KIRKLEES METROPOLITAN COUNCIL INVESTMENT & REGENERATION SERVICE

DELEGATED DECISION TO DETERMINE APPLICATIONS FOR CONSENT, AGREEMENT OR APPROVAL REQUIRED BY CONDITION

Reference No:	2025/44/91094/E
Site Address:	127, Marsh Lane, Shepley, Huddersfield, HD8 8AS
Description:	Discharge of details reserved by conditions 5 (foul, surface water and land drainage scheme), 6 (assessment of the effects of storm events), 7 (surface water drainage scheme), 9 (details of the junction and associated highway works), 11 (proposed internal adoptable estate roads scheme), 12 (construction traffic schedule) and 13 (survey of the highway on Marsh Lane) of previous permission 2024/91202 for erection of eight dwellings with associated access and external works
Recommending Officer:	Nina Sayers

DECISION – Discharge of Conditions – Split Decision

Access Junction Layout
Scale 1:100

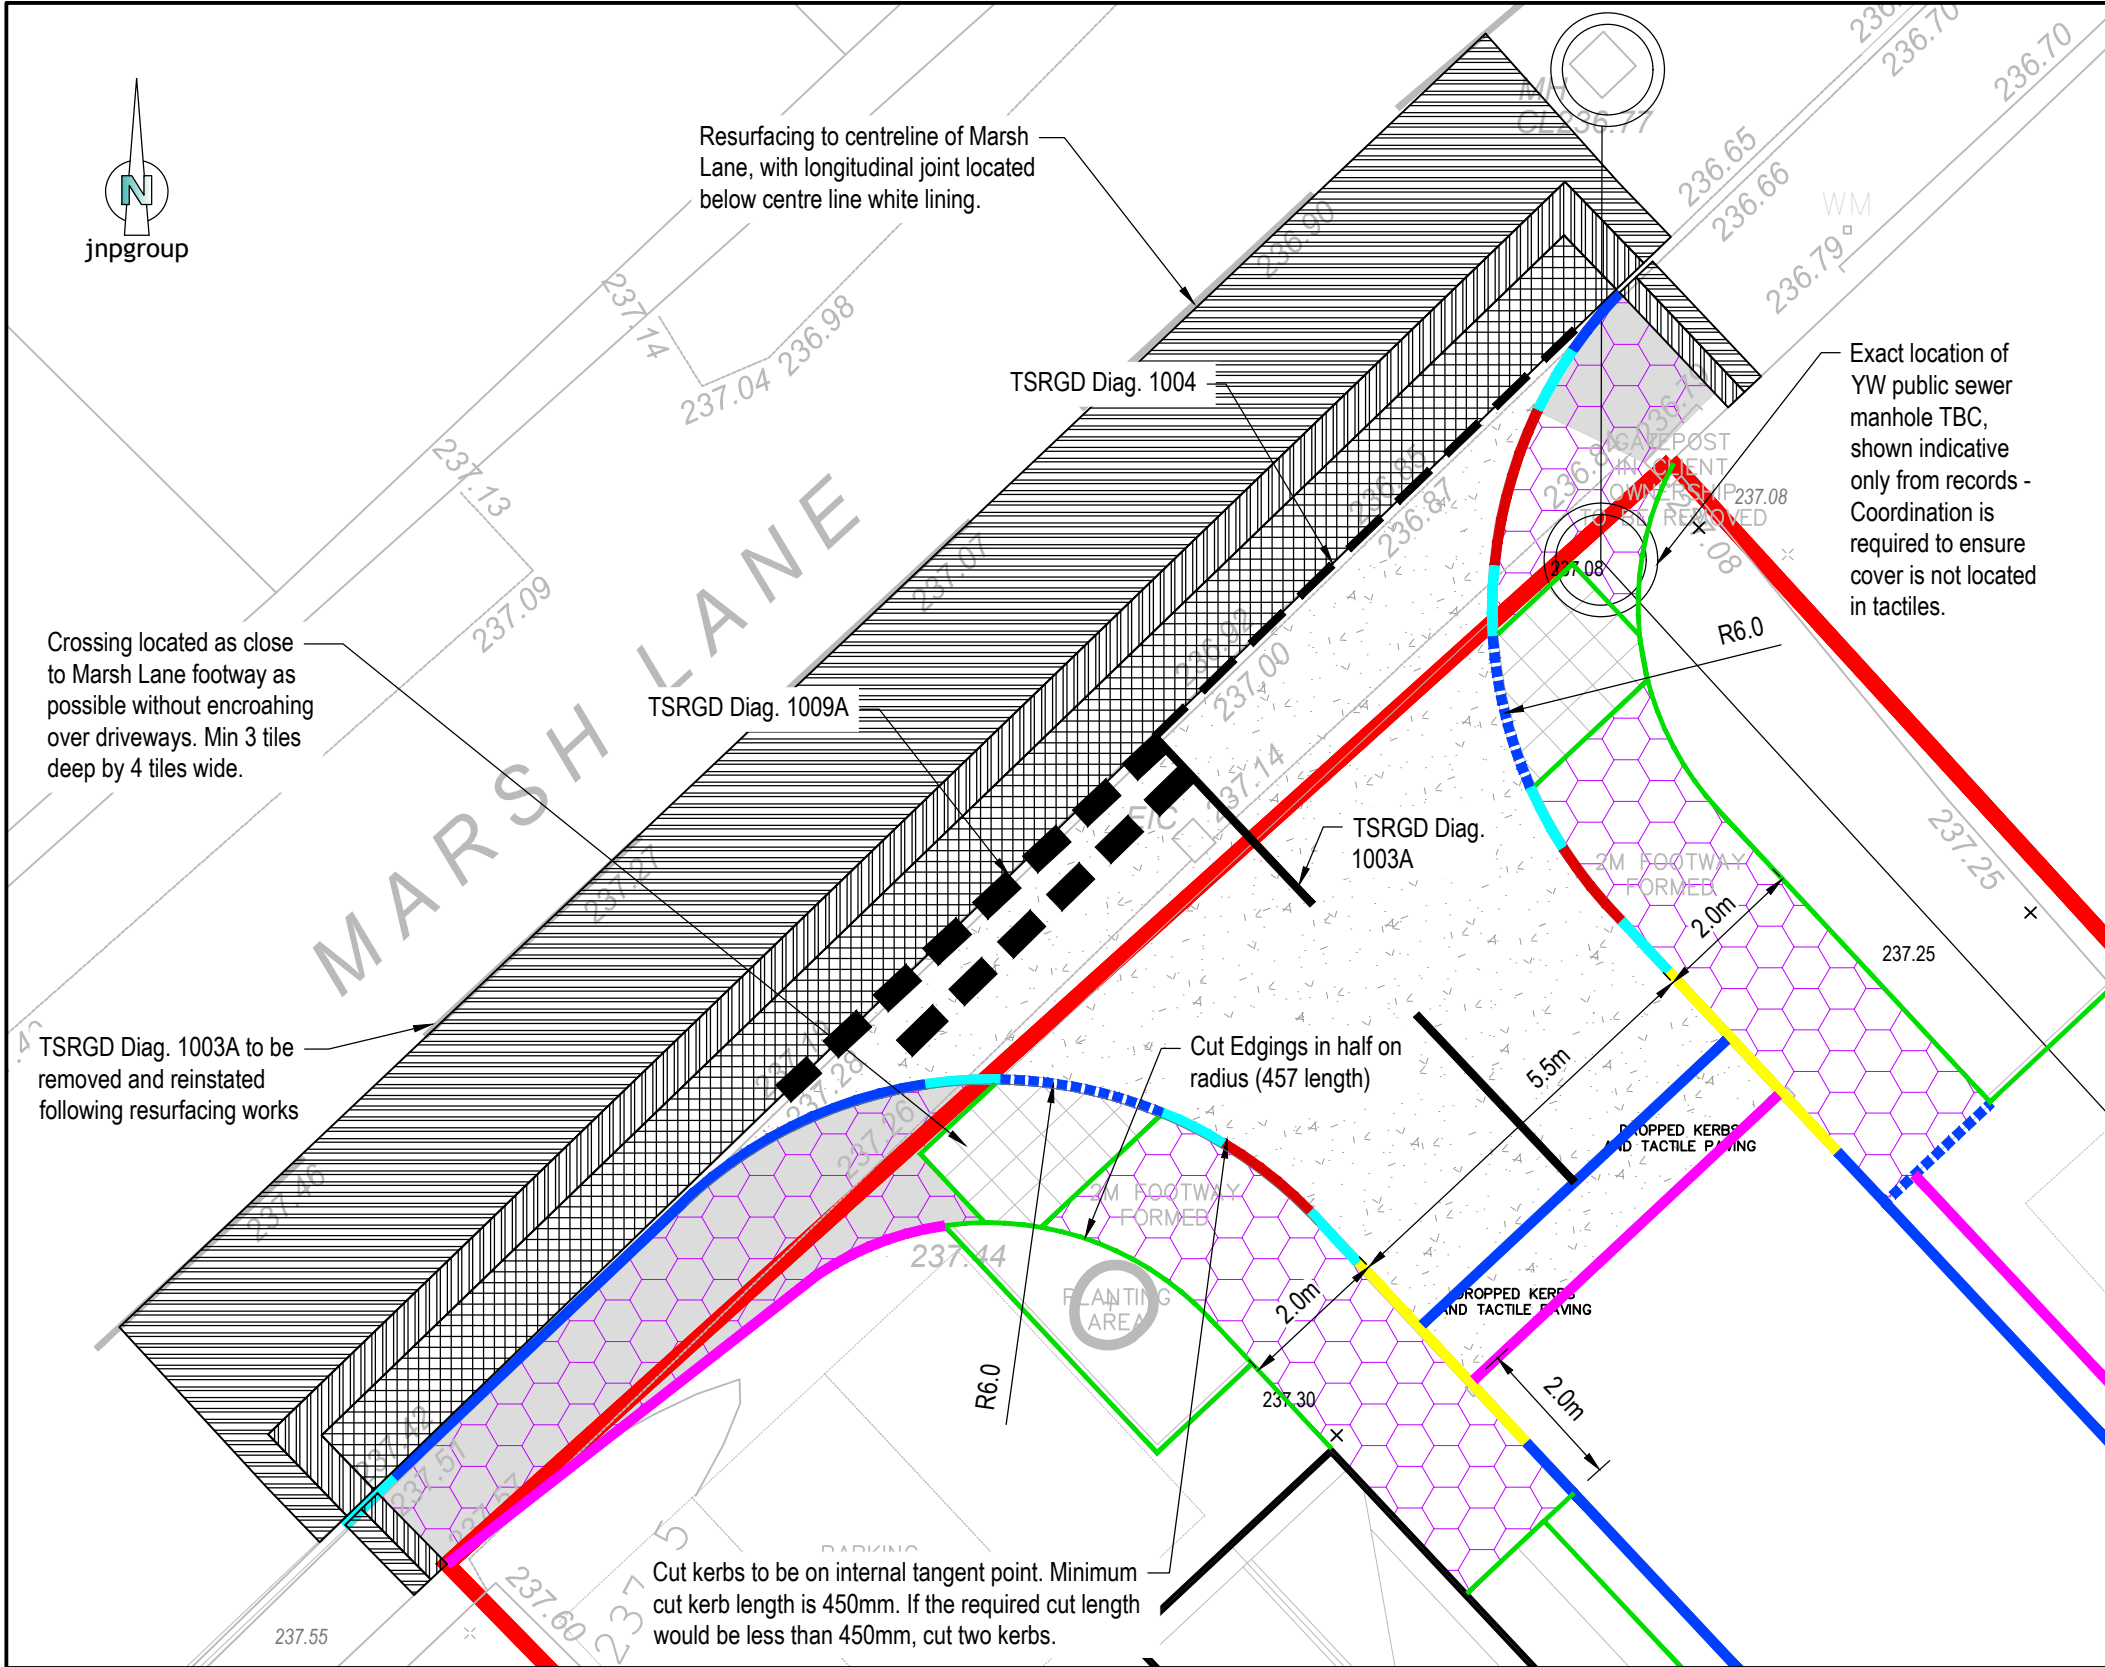
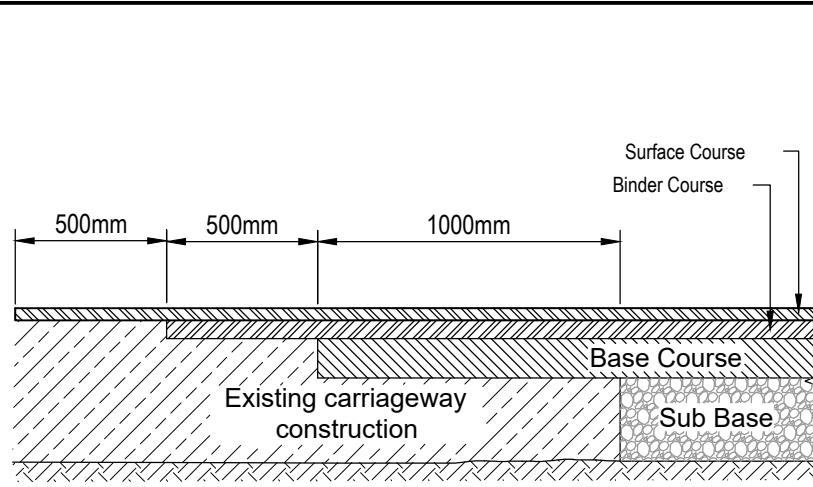
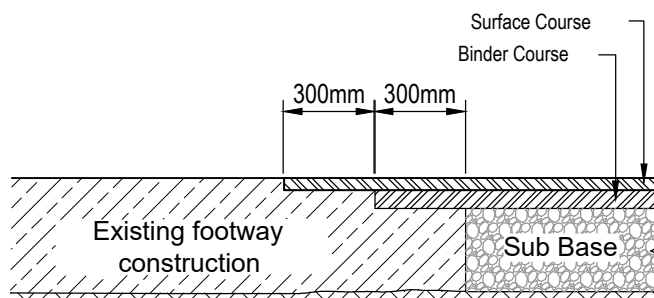
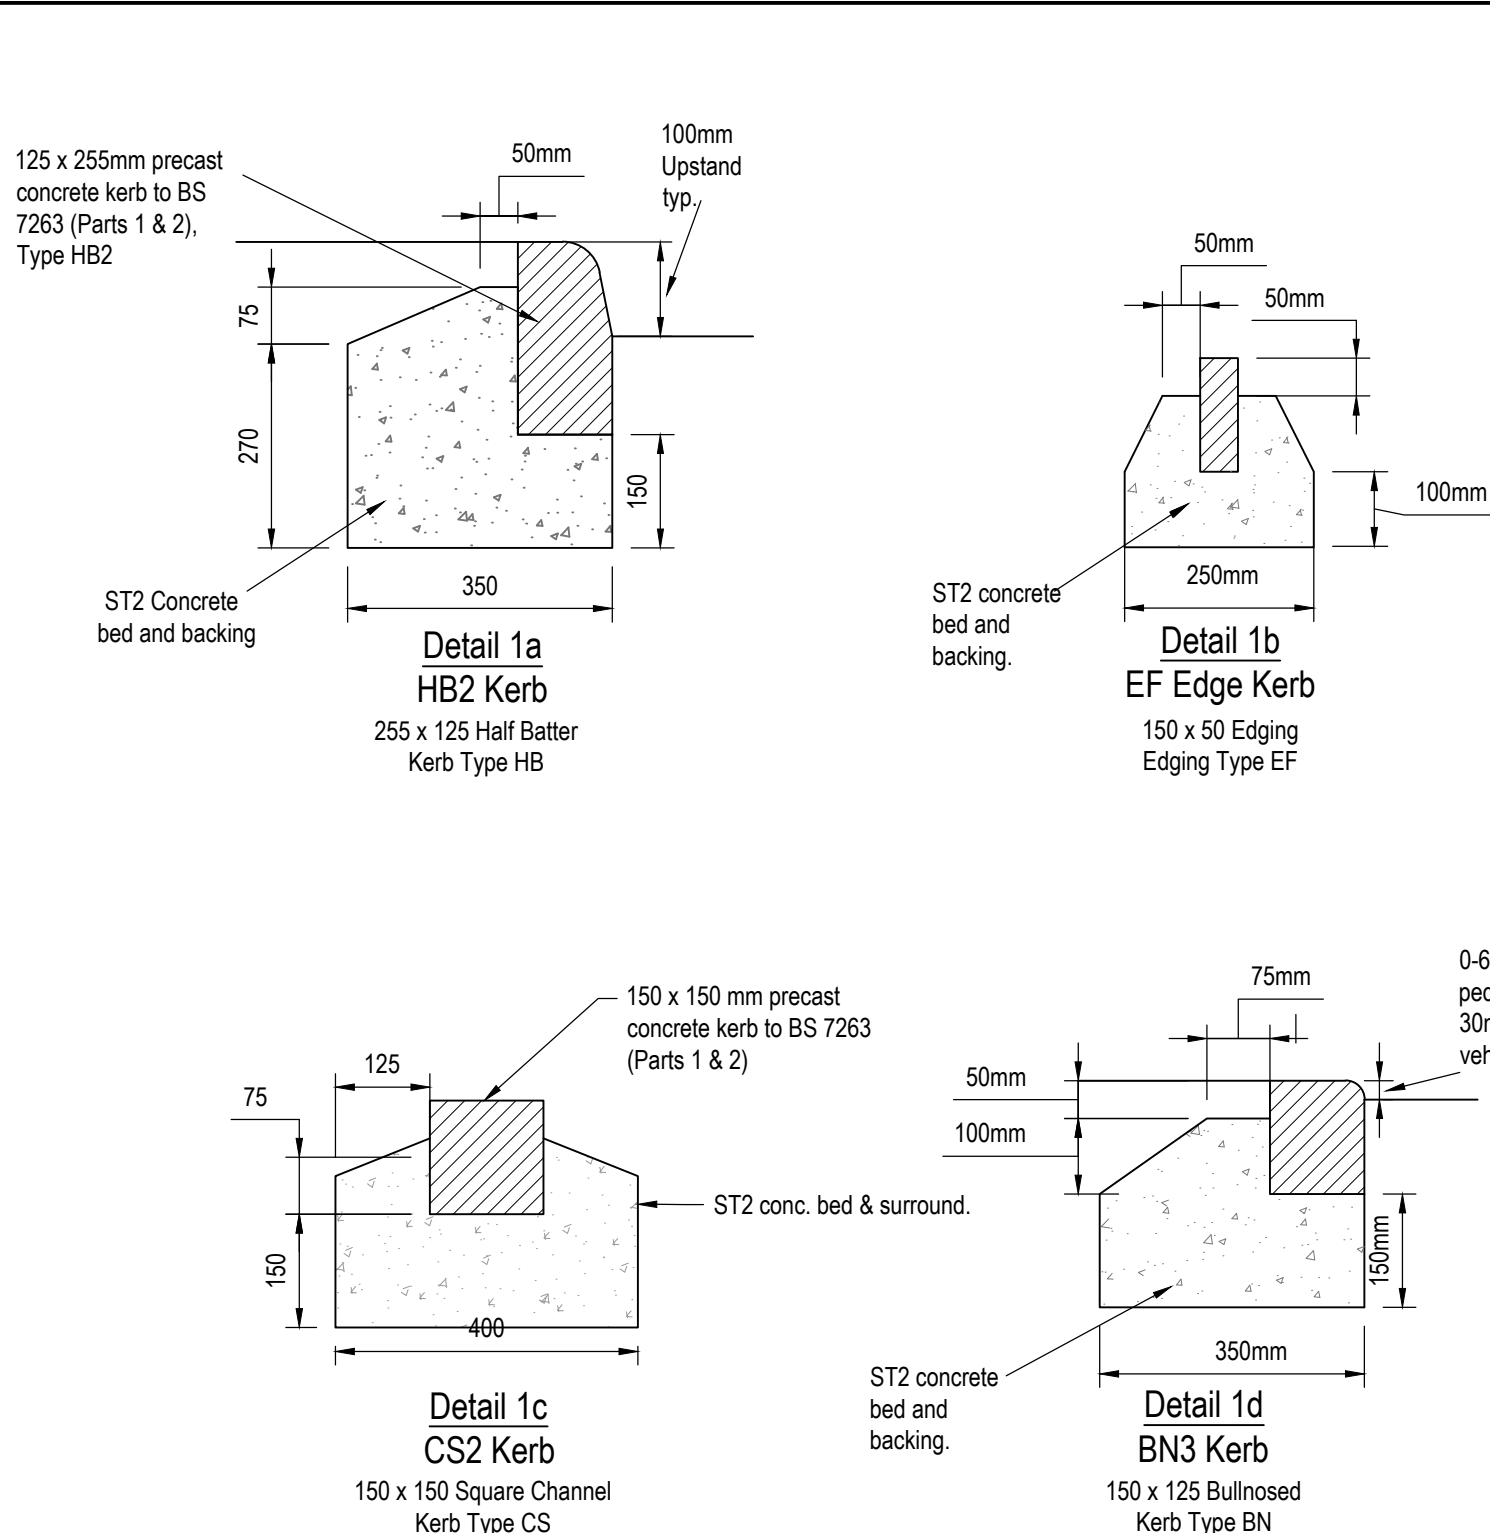
- B26074-JNP-XX-XX-DR-C-2005-P04

The submitted details have been reviewed and approved by the councils Highway Design team and are considered to be suitable for the discharge of condition 9.
